# CITY OF ALBUQUERQUE

October 2, 2017

**Re: I25 W. Frontage Rd and Venice Ave  
Erosion and Sediment Control Plan  
Engineer's Stamp Date 8-22-17 (B18E022)**

EROSION AND SEDIMENT CONTROL PLAN

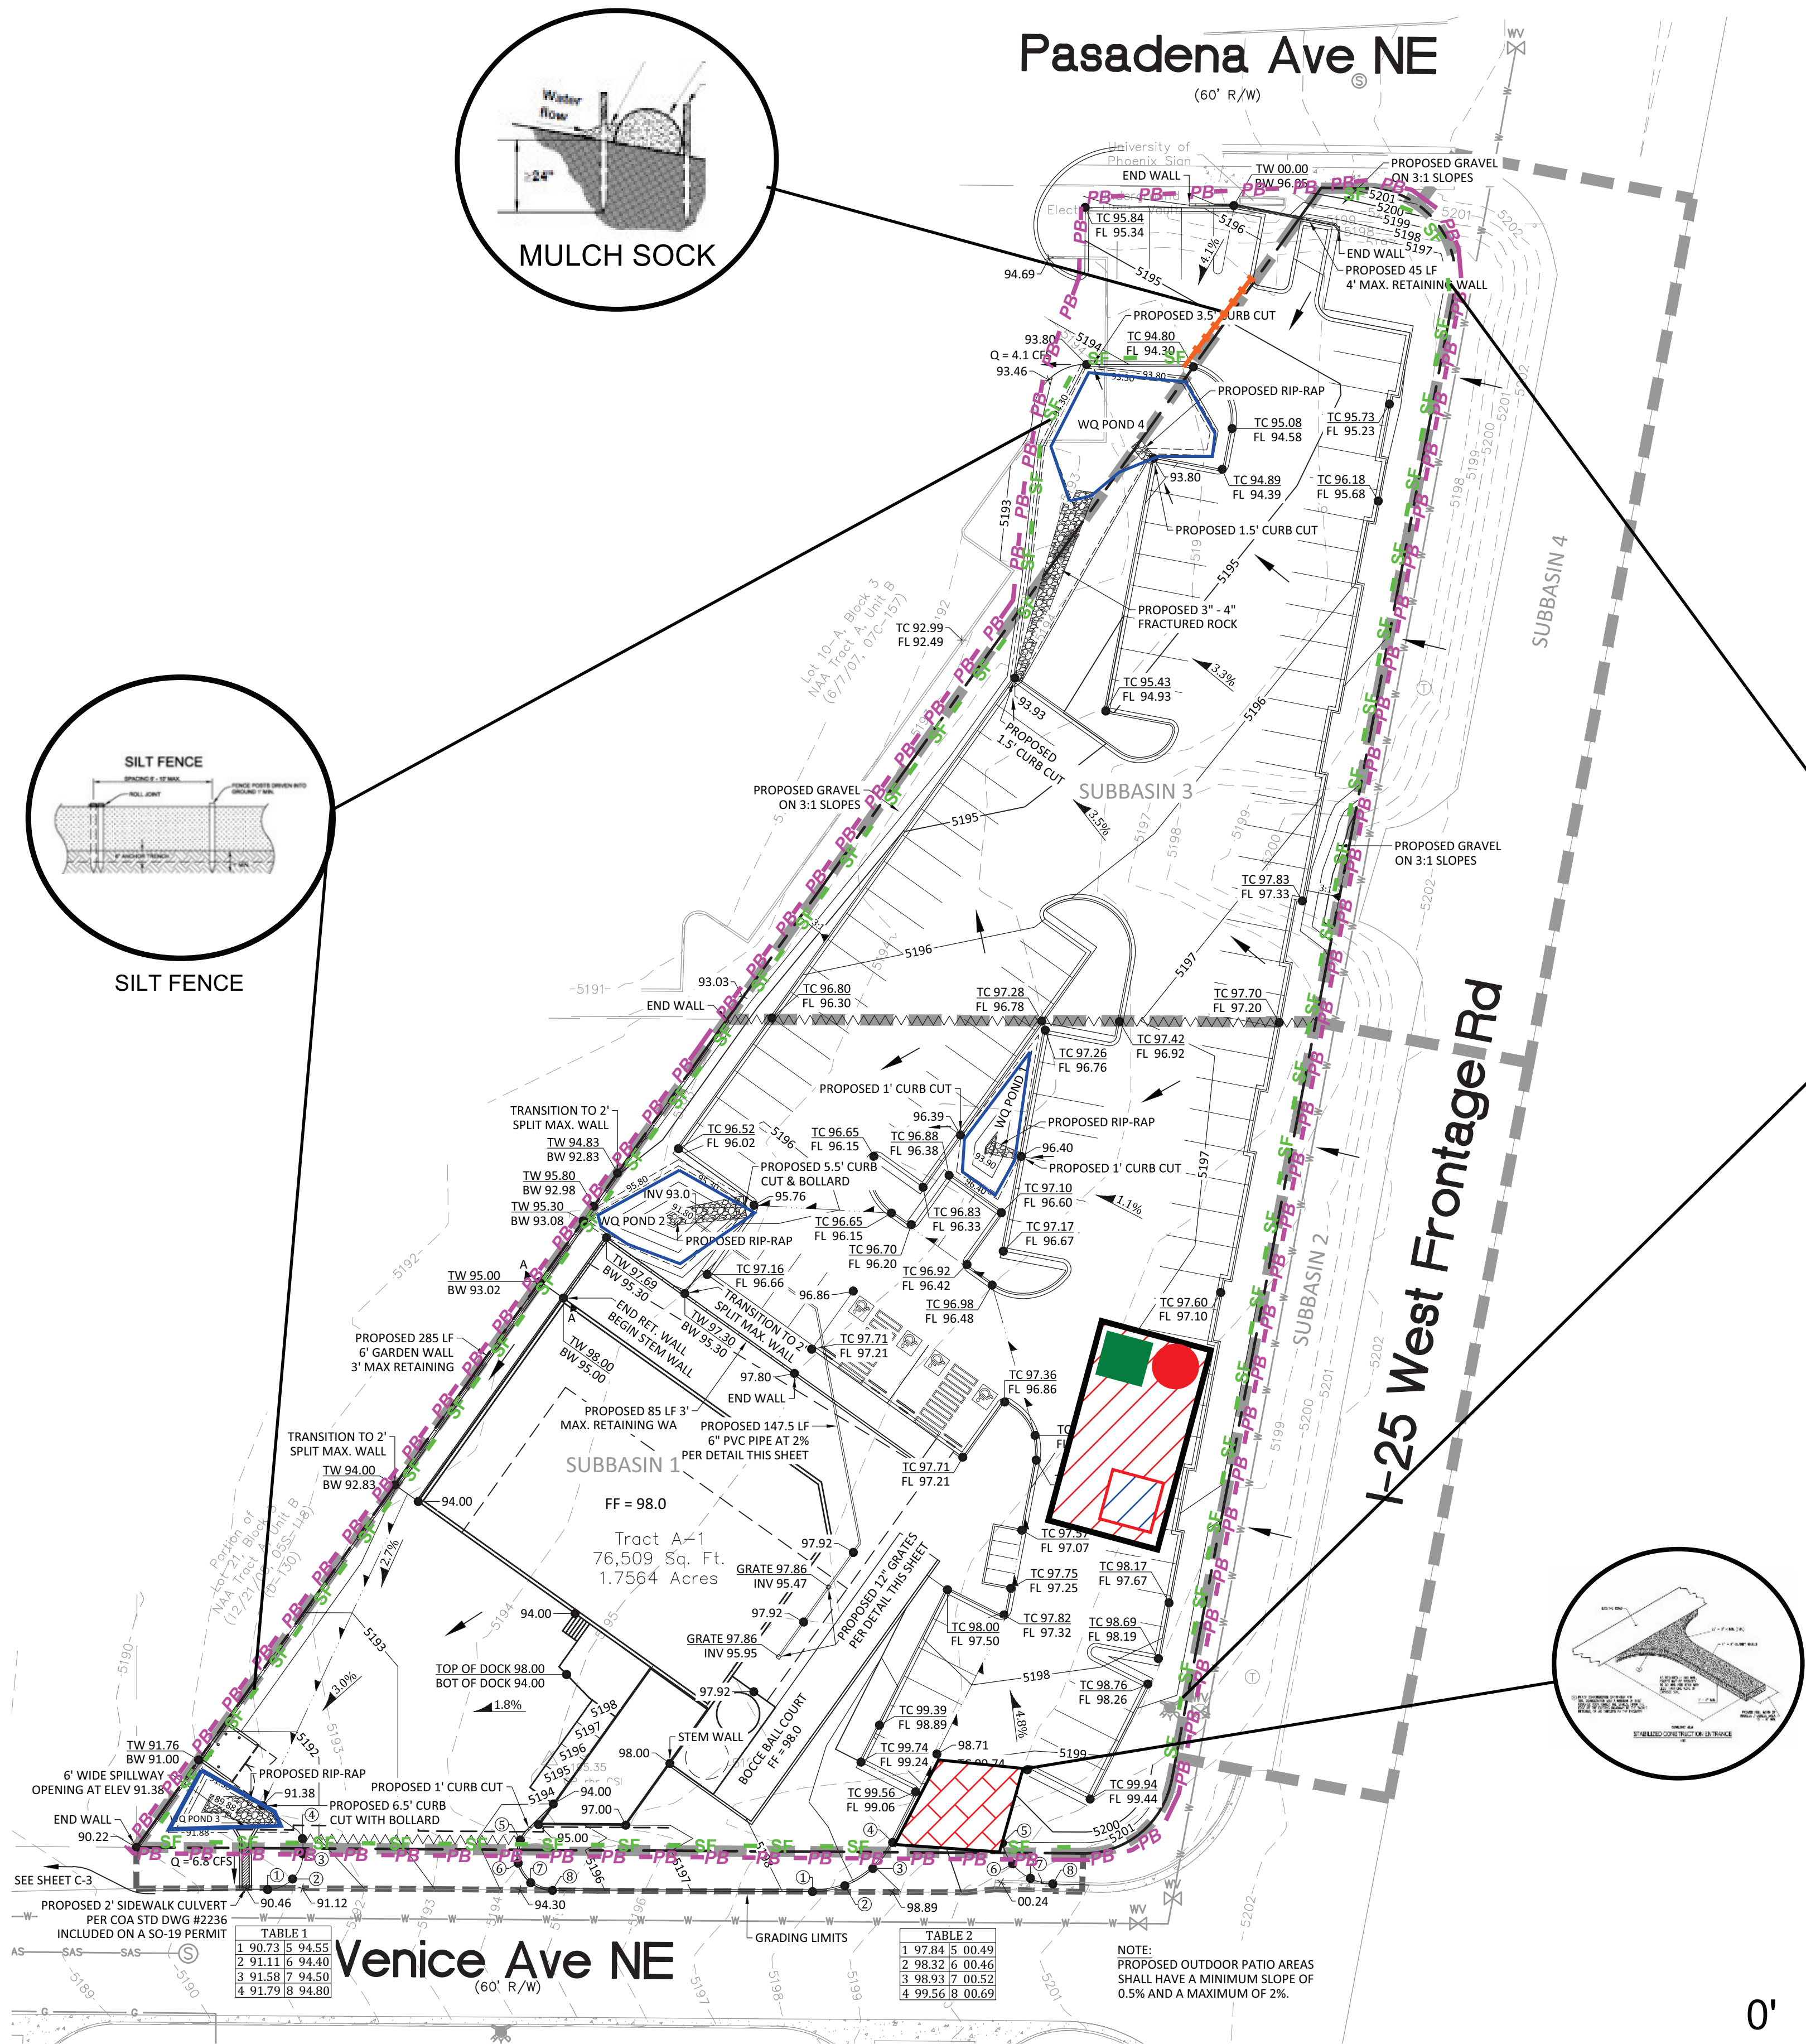
1. The grading plan shows an earthen swale from the southwest corner of Lot A1 350 feet west to two proposed inlets. Provide a BMP(s) for this work.
2. A cross-lot drainage easement is required from the property owner to the west. If not obtained, this will change the grading and drainage plan and therefore most likely the ESC Plan. Please wait to submit the revised ESC Plan until the easement issue has been resolved.
